CDS Planning and Development Consultancy

Planning Application
44 Murray Road, Northwood, HA6 2YL
Planning Application 1787/APP/2025/1849

I have the pleasure of attaching a formal amendment package which responds comprehensively to the points raised during our discussions. This letter summarises the key amendments and provides additional clarification where further information was requested.

GROUND

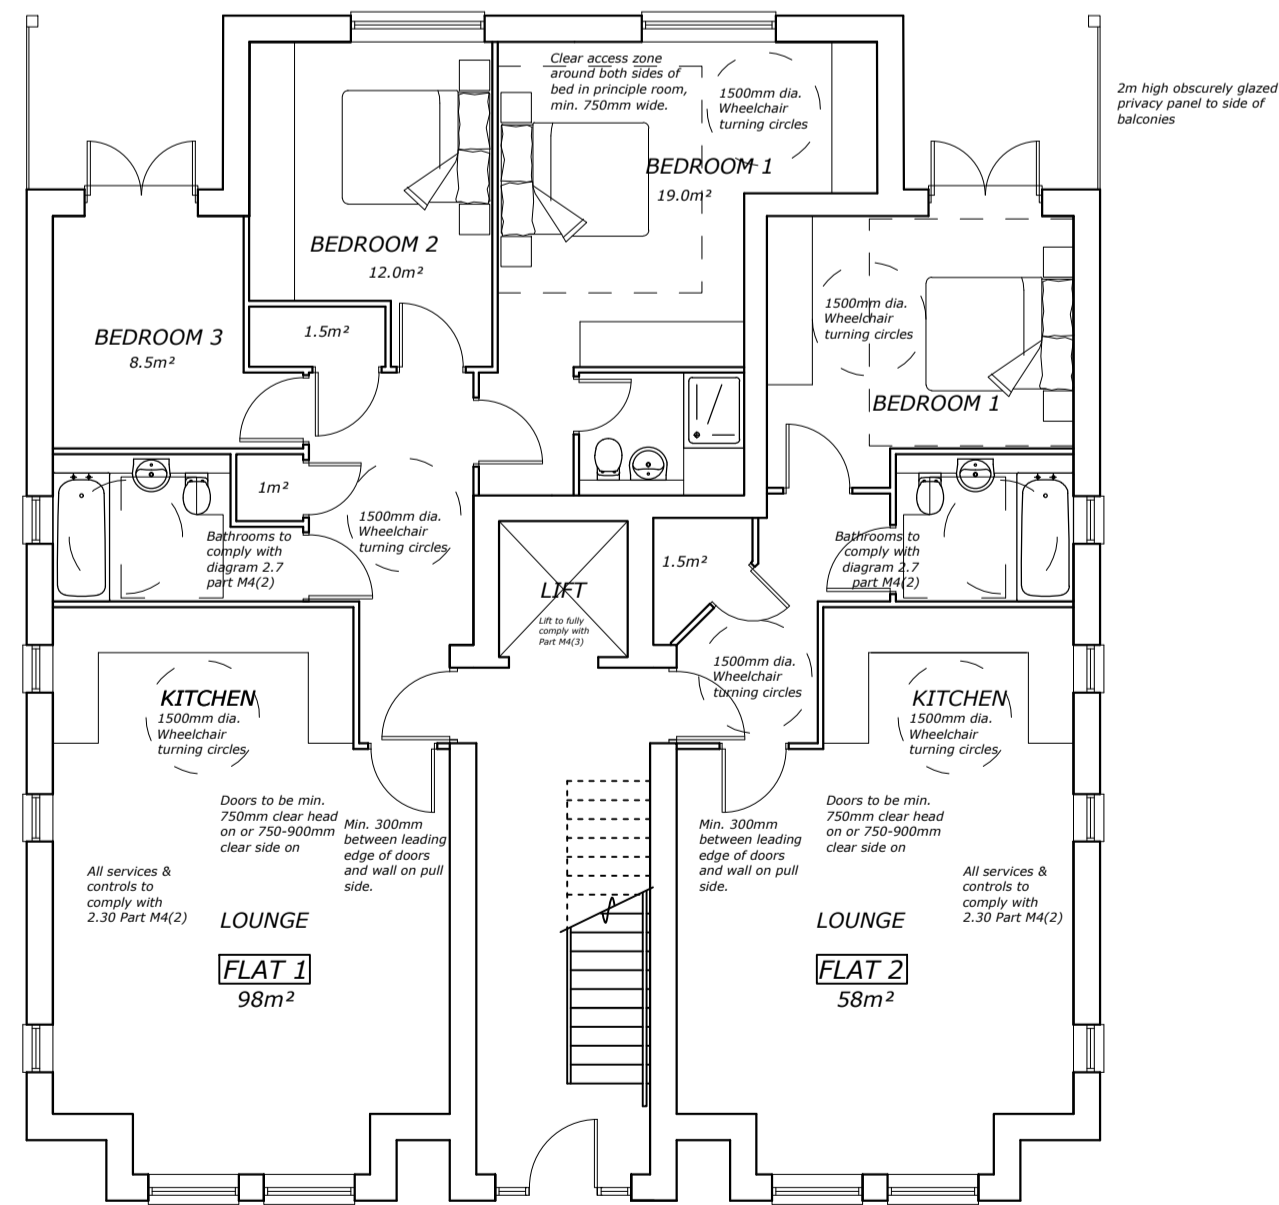
Officers requested clarification regarding the amenity of the ground floor flats, particularly those with bedrooms facing the communal rear garden.

In response, low-level fencing is now proposed, as shown on the site plan, to define and secure private amenity areas to the rear of Bedrooms 1 and 3 of the ground floor units. In addition, defensible planting and hedging can be introduced to the rear of the bedroom windows to further safeguard privacy. These measures will ensure a high-quality and policy-compliant level of residential amenity for future occupiers and could be secured via planning condition if considered necessary.

Section Through Lift

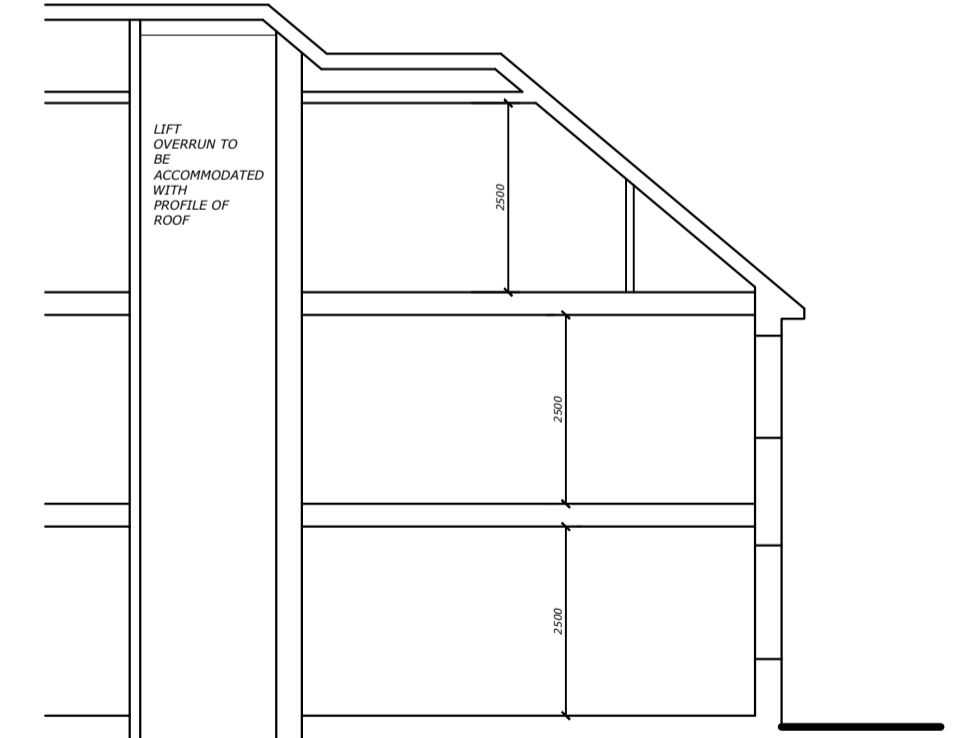
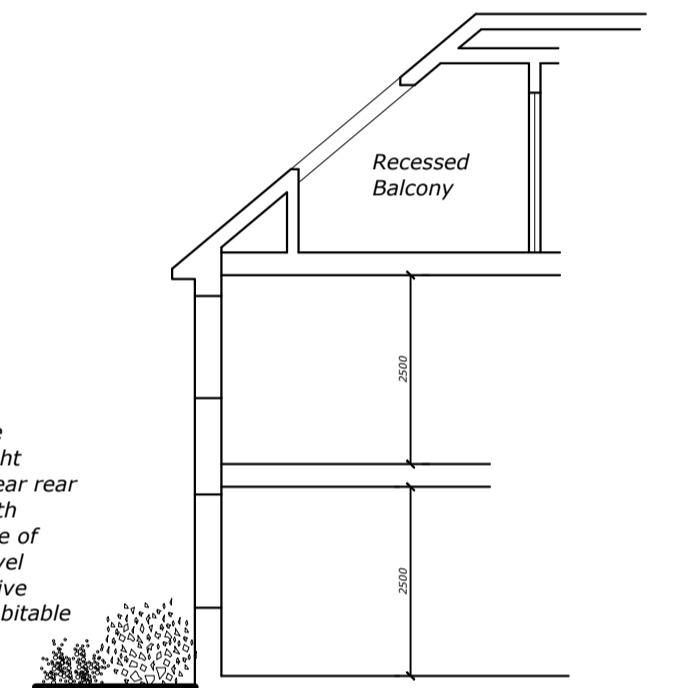
Further details were requested regarding the recessed balconies and the dormer to the rear.

Confirmation was requested regarding internal floor-to-ceiling heights.

Sections have now been provided as part of the submission to clarify these elements.

A building cross-section has now been included within the submitted drawings, demonstrating that all units would achieve an internal ceiling height of 2.5 metres, thereby complying with London Plan Policy D6.

PLAN FOR 10 No. CYCLES

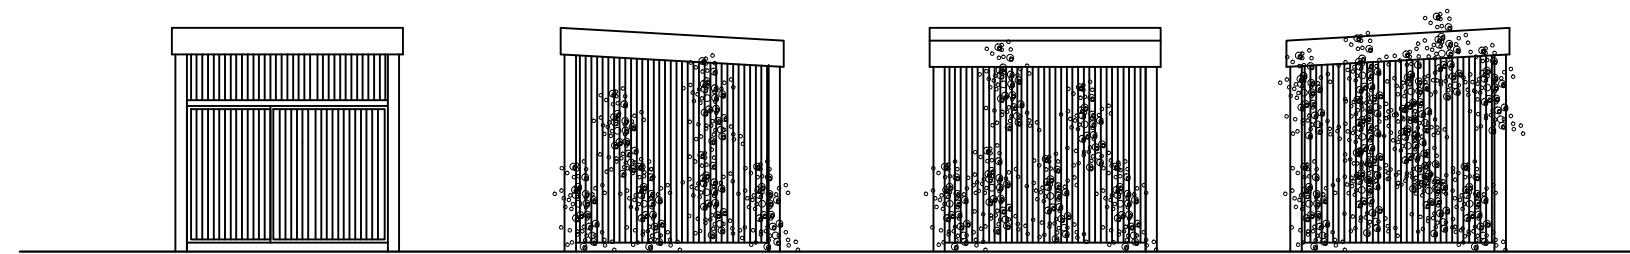
Clarification was also sought regarding the positioning of the cycle store and refuse areas adjacent to the amenity space.

Further details are now shown on the revised site plan illustrating how residents would access these facilities, together with details of the cycle store itself. Access routes would be hard landscaped to ensure usability in all weather conditions.
